RE: MP09_0066 THOMAS STREET CAR PARK SITE CHATSWOOD MODIFICATION 9

I refer to the notification of the application for Modification 9 of the Thomas Street Car Park development approval MP09_0066 and note that the modification concerns the design of the basement car parking levels and delivery access to the site.

GROUND FLOOR PLAN

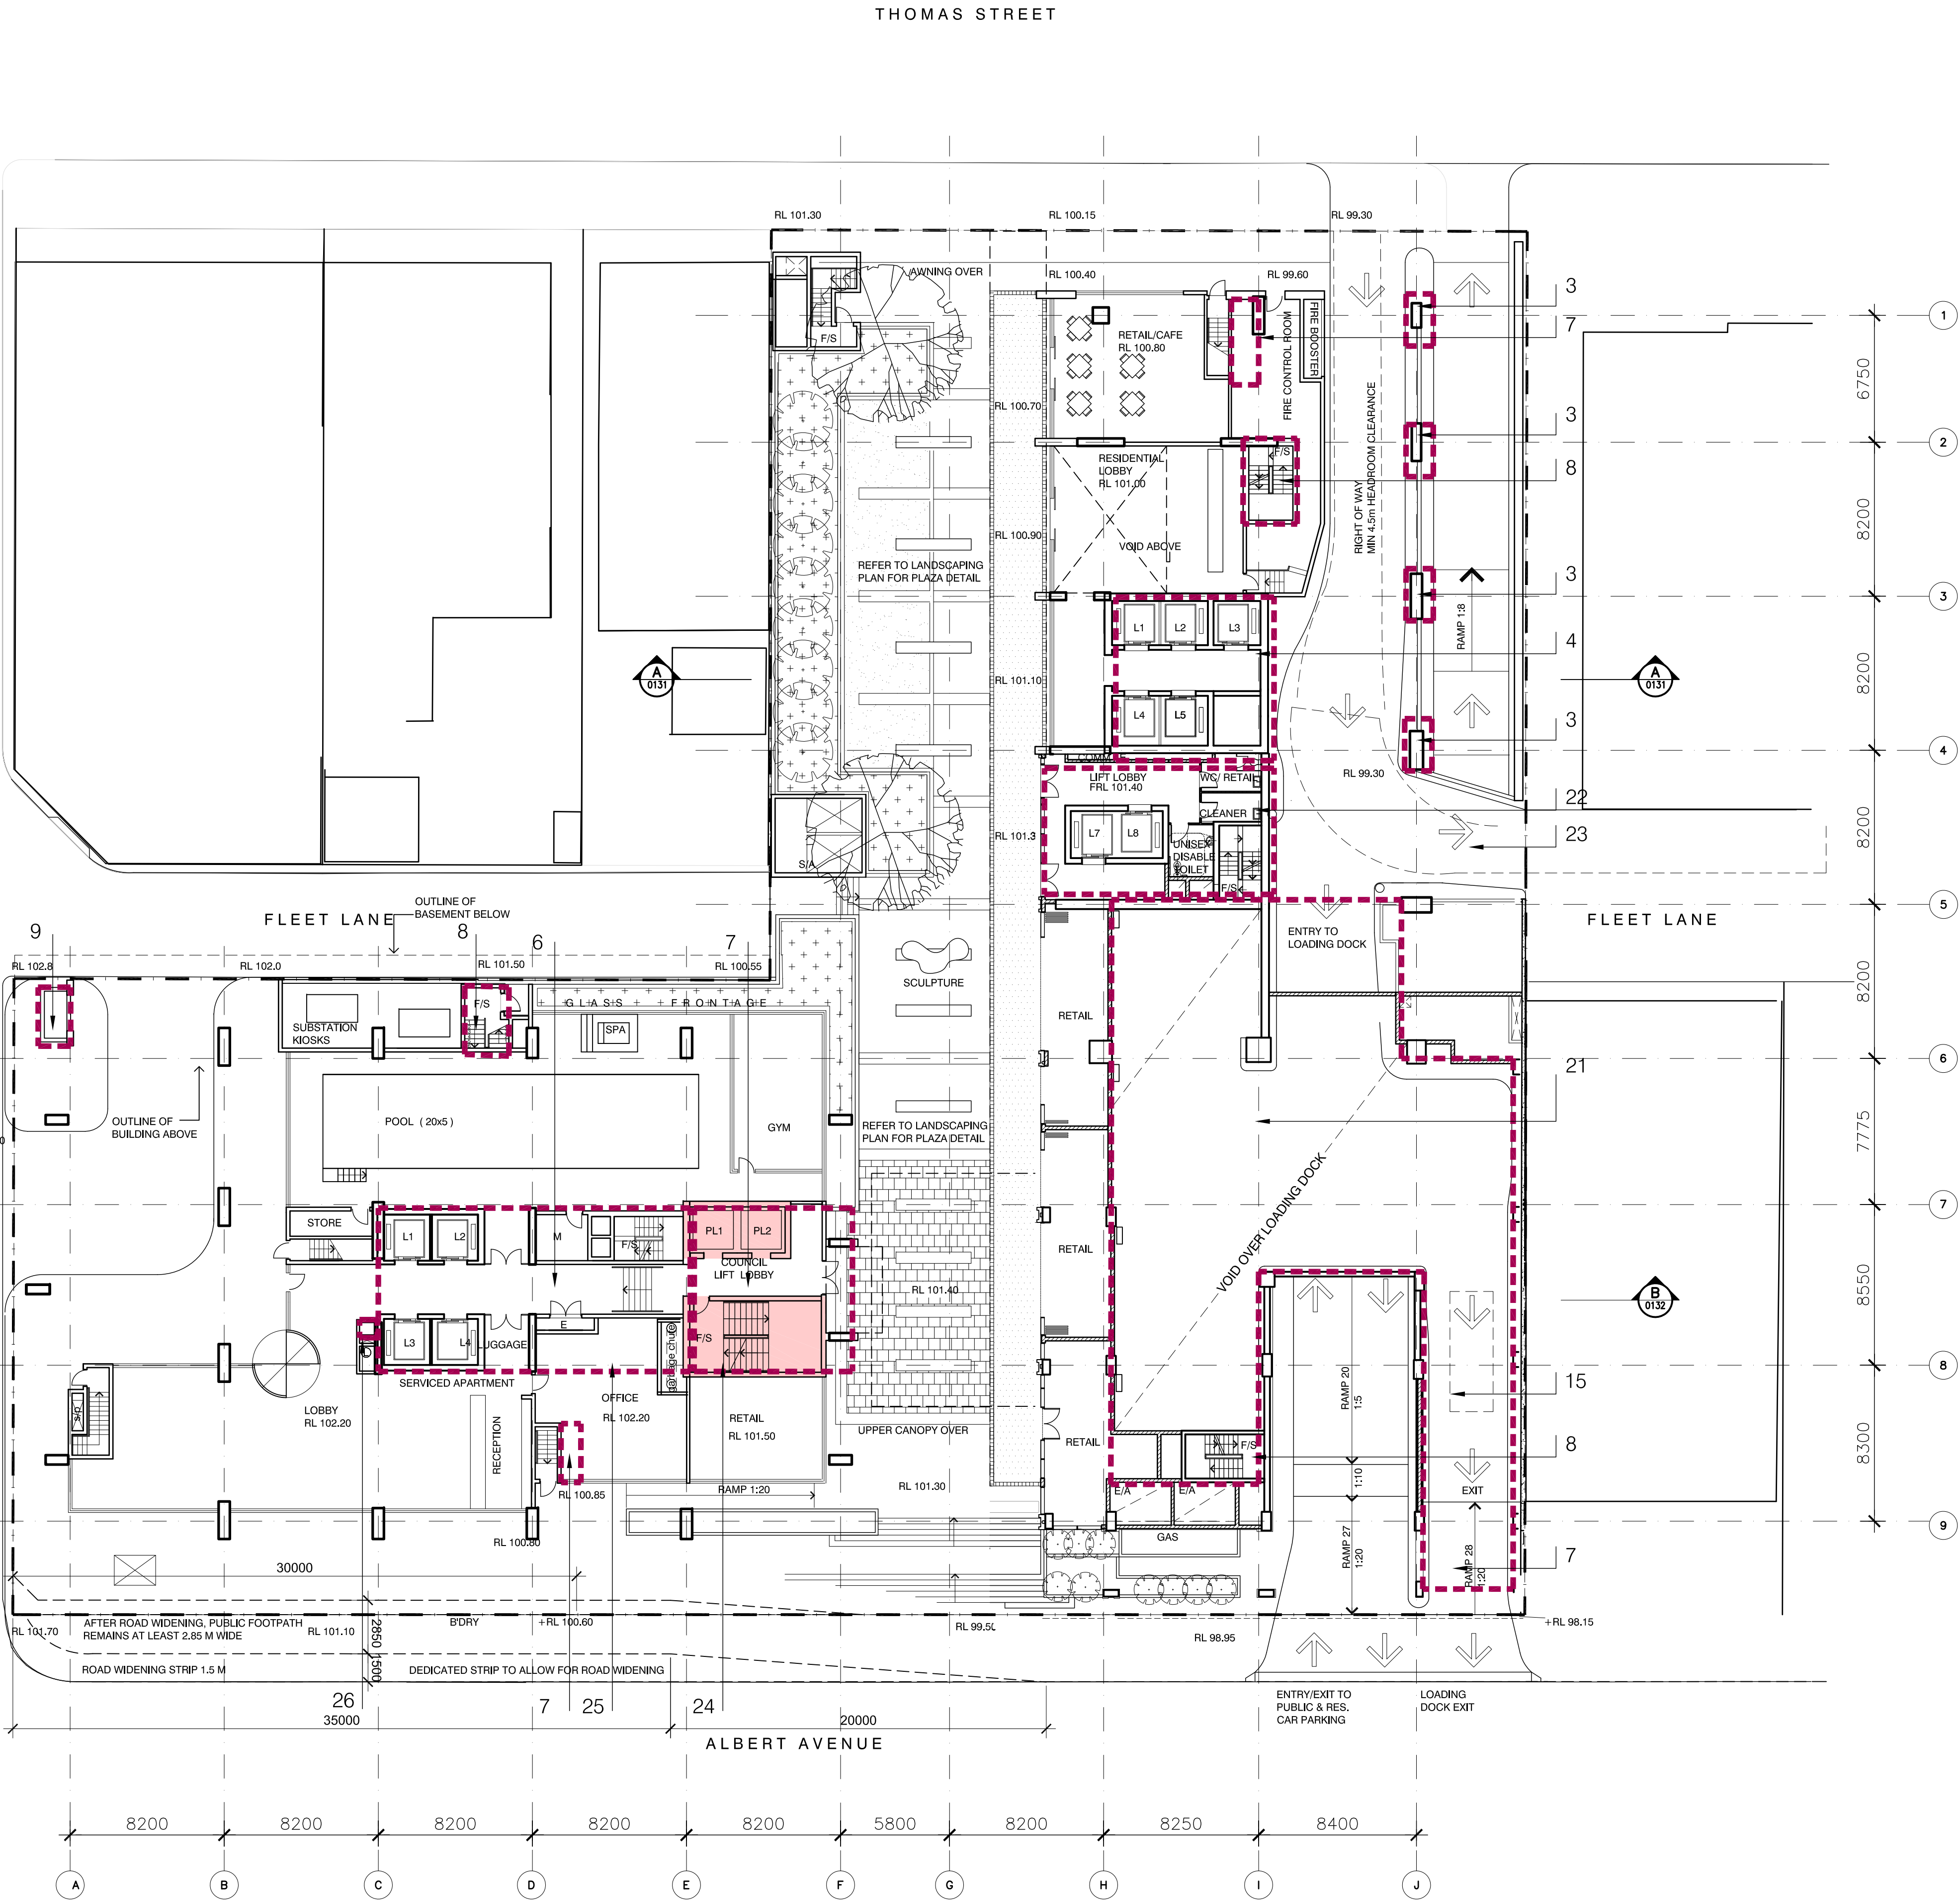
2. There is no transition provided at the end of car park entry ramp. The maximum change in grade is 15% to avoid vehicles scraping.
3. Separation of the car park entry and exit lanes to Albert Avenue was to be provided and is not shown. Such separation is not to extend such that it obstructs the public footpath.

6. Only a 3 metre wide entry is provided to the car park such that left in left out only must operate in Albert Avenue. A median is required in Albert Avenue to stop the right turn movement into the car park.

7. To ensure a vehicle can enter the car park from the left lane in Albert Avenue, the crossing of the footpath requires a splay widening of 1.8 metres. It is noted that the footpath is to be a consistent grade for pedestrians in accordance with Council's requirements in Chatswood CBD.

SP 7

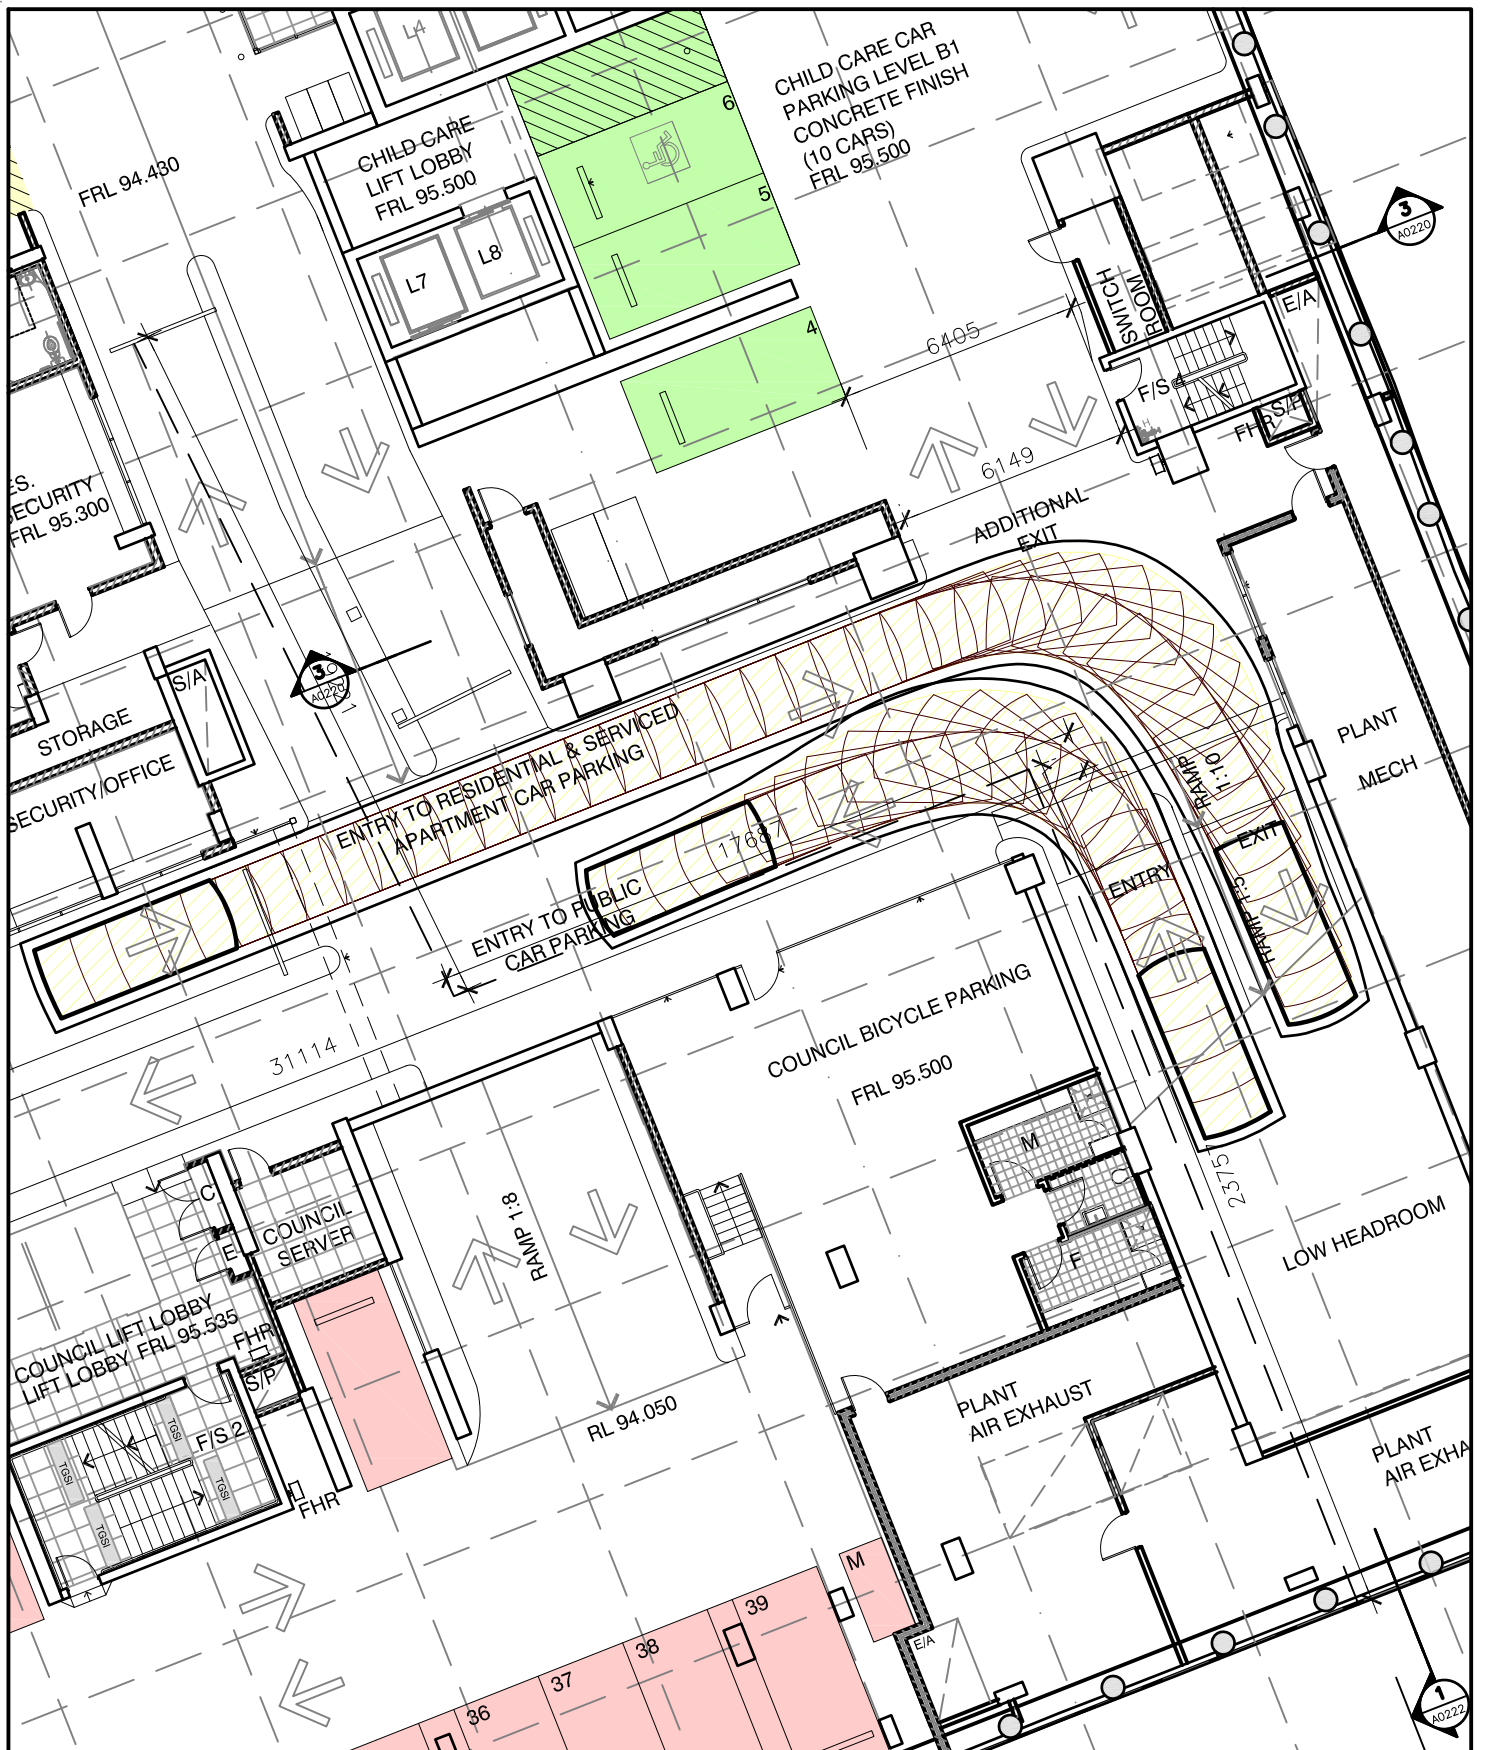
1. The swept paths for trucks (including Council's refuse truck) for manoeuvring and exiting the site and B99 vehicles using the exit to Thomas Street indicate that vehicles will hit or have to mount the kerb and potentially hit the wall especially SP7, SP10 and SP12.
